3/2022/1134

Application for a non-material amendment following a grant of planning permission.
Town and Country Planning Act 1990

CONSERVATORY TO THE REAR OF THE PROPERTY

3/2022/0844

PROPOSED ELEVATIONS

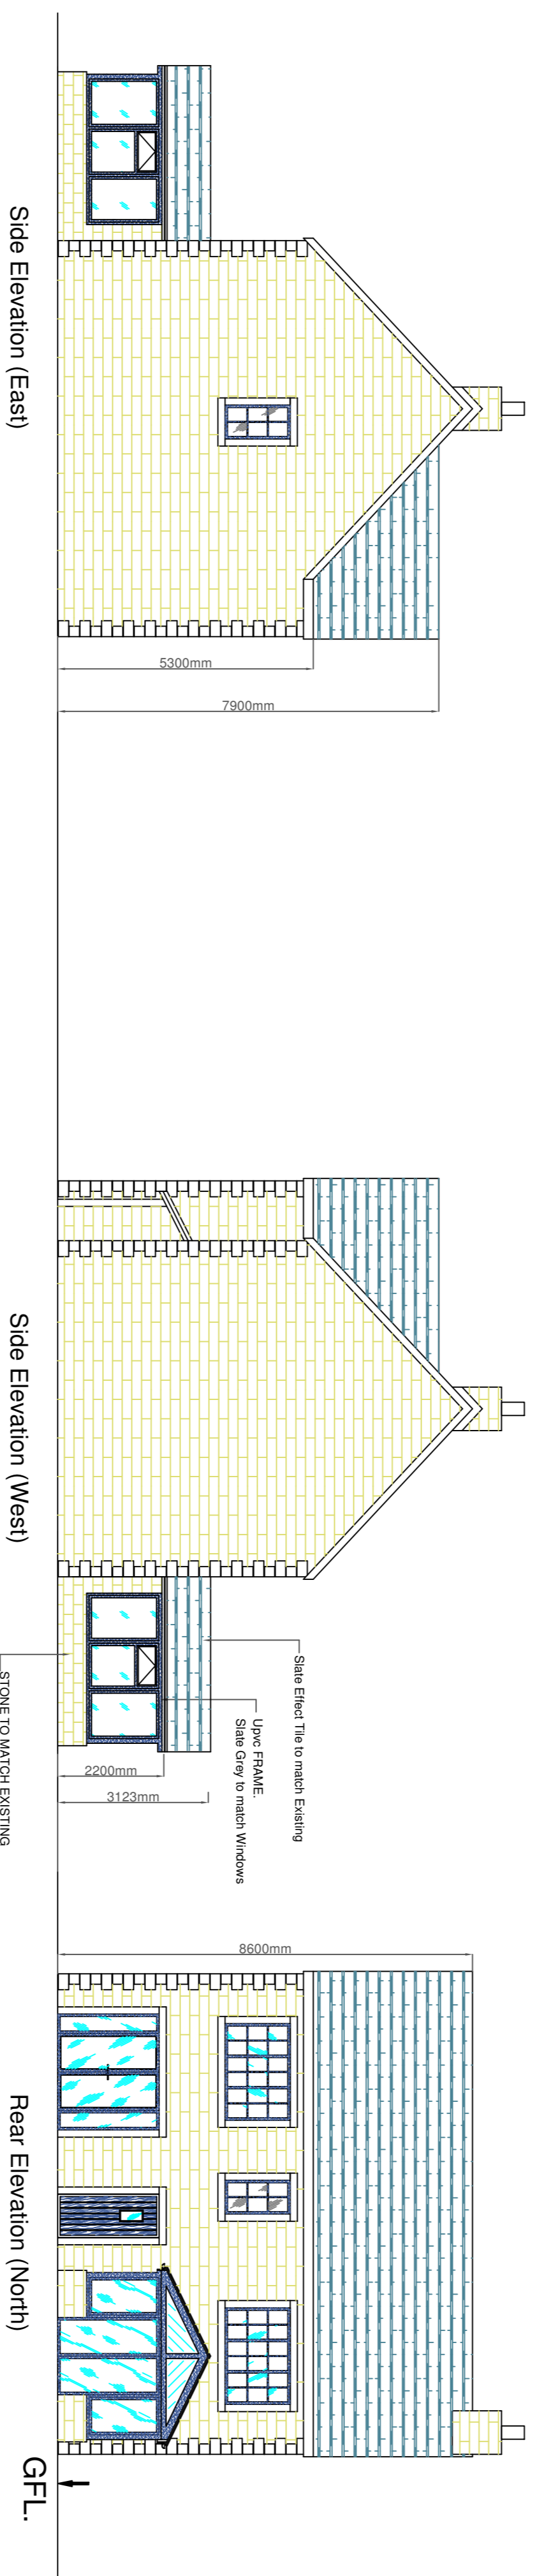
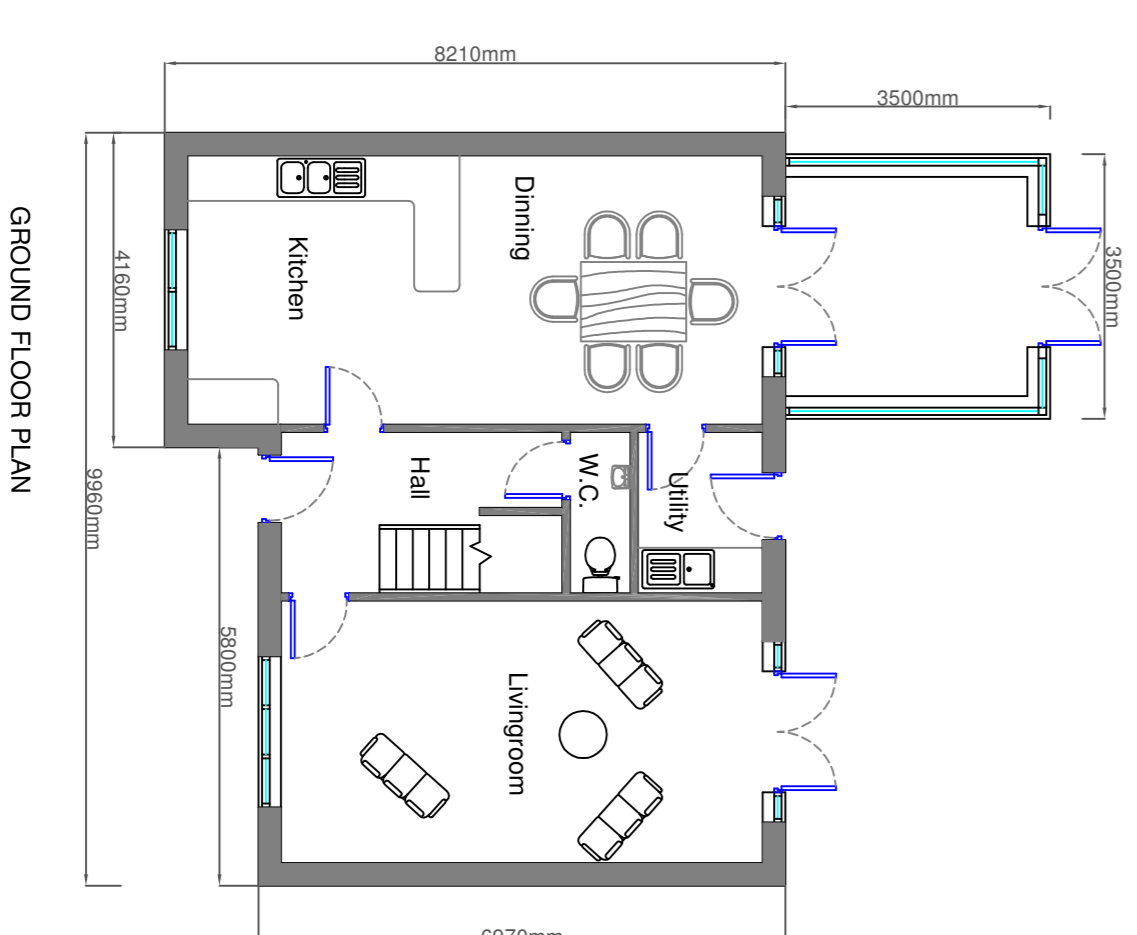
WE WOULD LIKE TO ADD 2 GLASS PANELS INTO THE ROOF AND CHANGE THE WINDOW DESIGN INTO 4 SECTIONS INSTEAD OF 3 SECTIONS.

THE UNITS ARE TO PROVIDE LIGHT INTO THE KITCHEN. SPLITTING THE FRAMES INTO 4 FROM 3 IS TO REPLICATE THE SIZE OF THE WINDOWS ON THE HOUSE. ALSO TO GET RID OF THE TRANSOM AND HAVE FULL LENGTH WINDOWS.
